Copy of email from Peter Cleveland to Andy Parish of Wates. The answers to Peter's questions are highlighted in red.

**Ref: R/287/10/ Installation of AC condenser to rear wall of store.
58 The Street, Rustington**

Drawing Title
Ground Floor
Proposed Layout
& Elevations

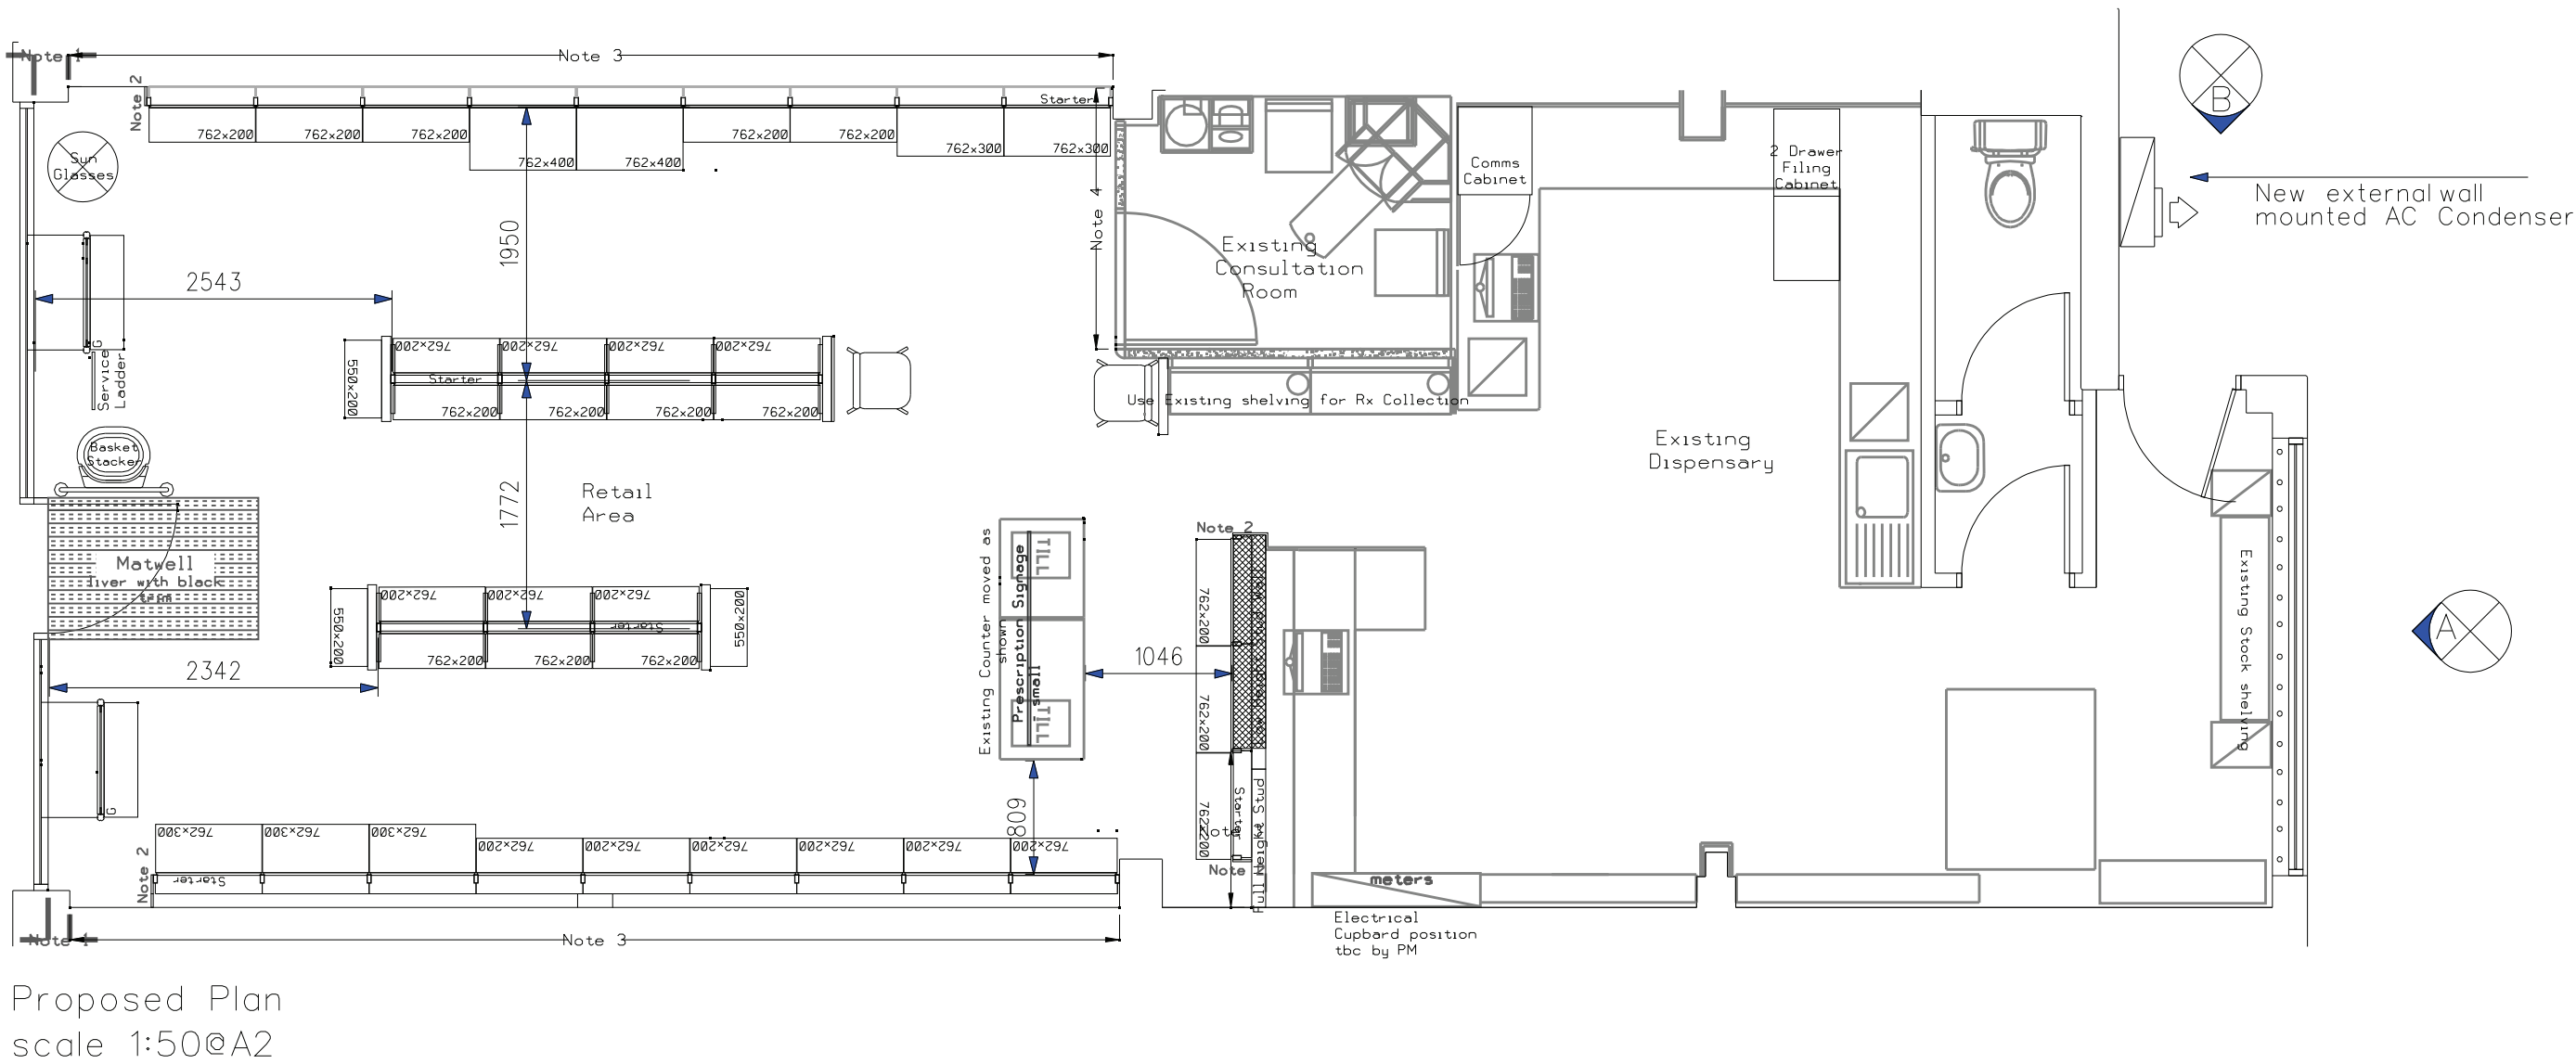
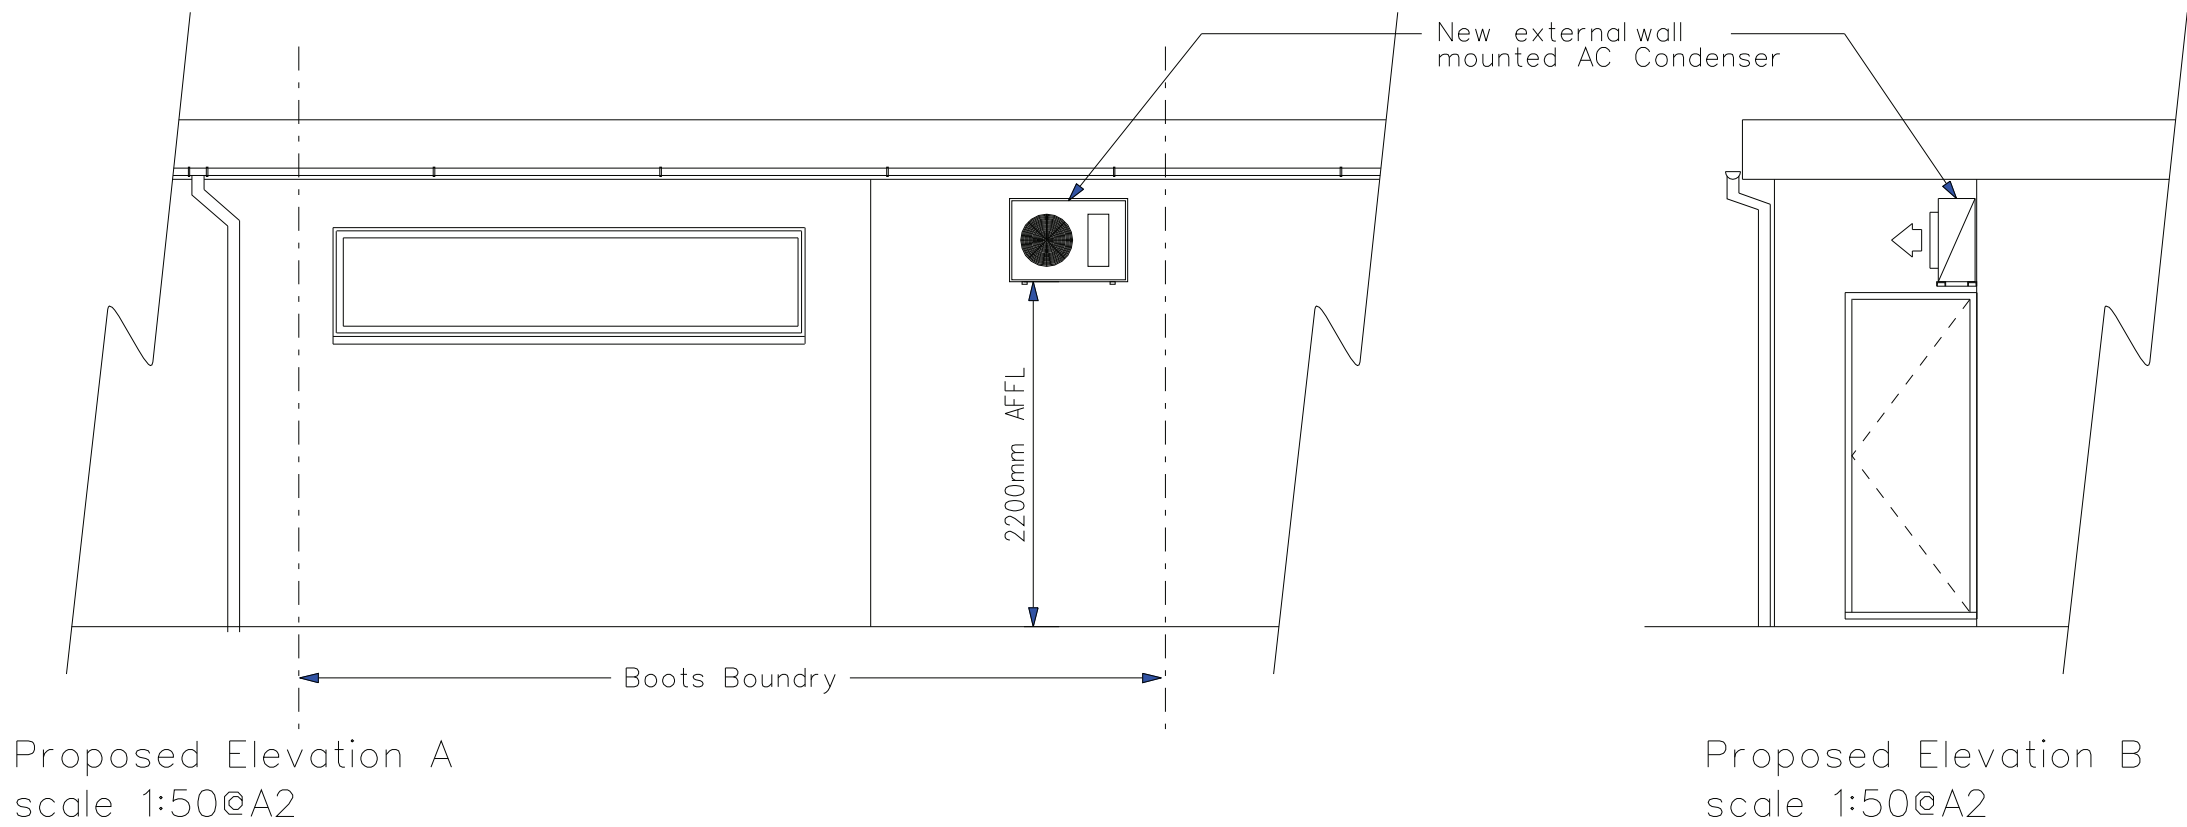
Insufficient information is available to assess the significance of noise from the a/c unit. Please confirm the following:

1. Distance from unit to the nearest noise sensitive facade.

2. Distance at which reported sound pressure level was determined.

3. Proposed hours of operation of the a/c unit.

Distance to the closest noise sensitive facade is circa 9-10m

The distance at which the sound pressure level was determined was 500mm from the AC unit. At 50db the noise emitted from the AC unit is no louder than normal conversation levels.

The AC would only be in operation during the store opening hours which are
Mon - Fri 9 - 5.30
Sat 9 - 1.00
Sun Closed
